From: Gillian Dillon [REDACTED]
Sent: 02 June 2019 15:31
To: Amber Willard
Cc: [REDACTED]
Subject: Planning Application BE/47/19/PL

PROPOSED SITE LAYOUT 1:200

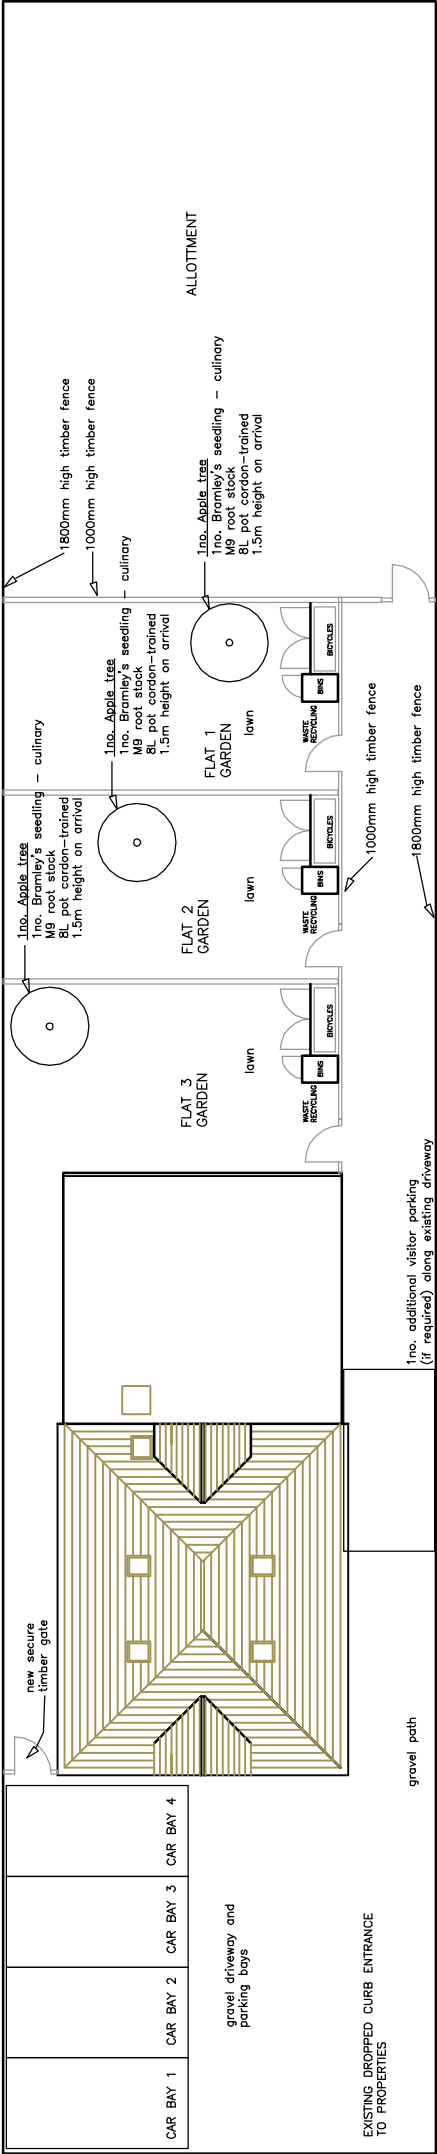
Further to our conversation on Friday, I would just like to reiterate my concerns regarding the allotment to the rear of the garden, which I feel would further increase the need for additional parking. Also within the new document I notice that they are proposing visitor parking to the side of the property.

How can they ensure that this is purely for visitor parking and not used by residents as additional parking, as this is quite close to my property.
